SP19006-R2-LOI-redlines.pdf Markup Summary

SP19006-R2-PP-redlines.pdf Markup Summary

RE: Saddlehorn Ranch
20 Shavano Park

SHEET TITLE: SITE PLAN (NORTH)
SHEET NO. 2
2 OF 5 SHEETS
FILE NO. SP-19-006

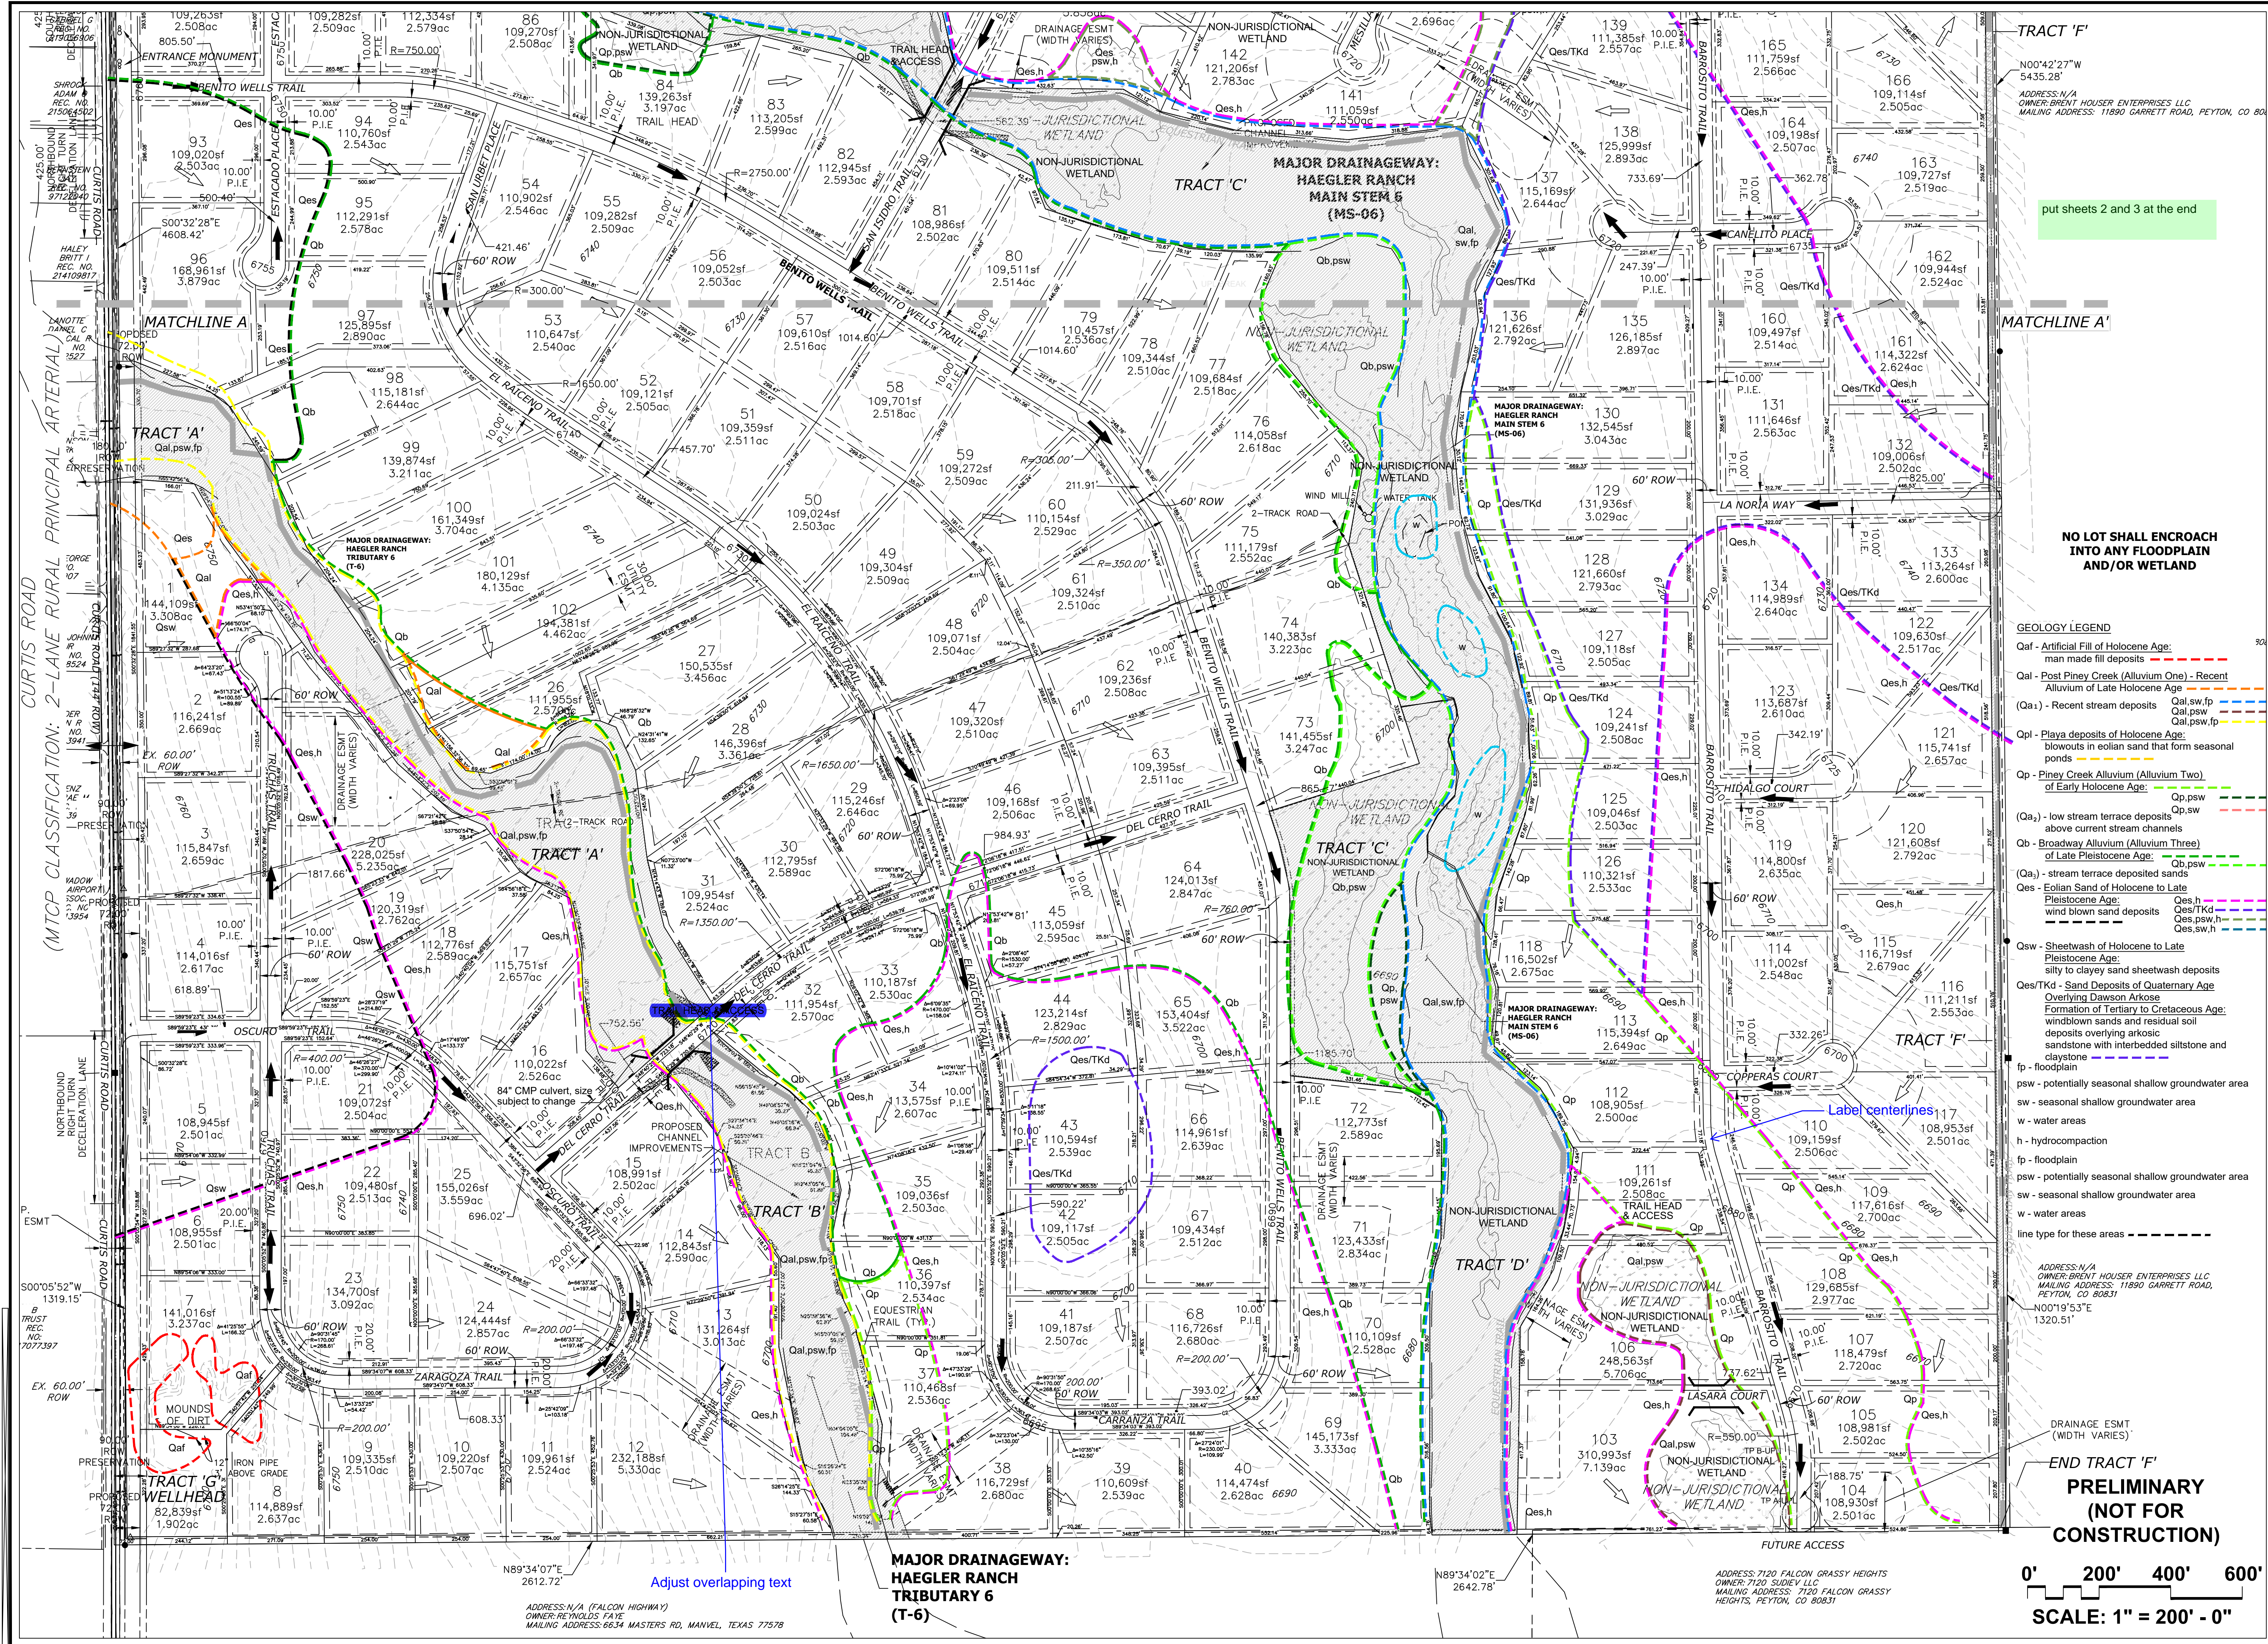
not all areas have descriptions.

applicable to all sheets: show the 200' setback line
where the front lot line is not 200'

applicable to all sheets: add net land area where
there will be no build areas to determine that all
lots are buildable.

Show and label 90-foot easement.

Label Elbert Road; Access needs to align.

Provide labels

label proposed type of facilities
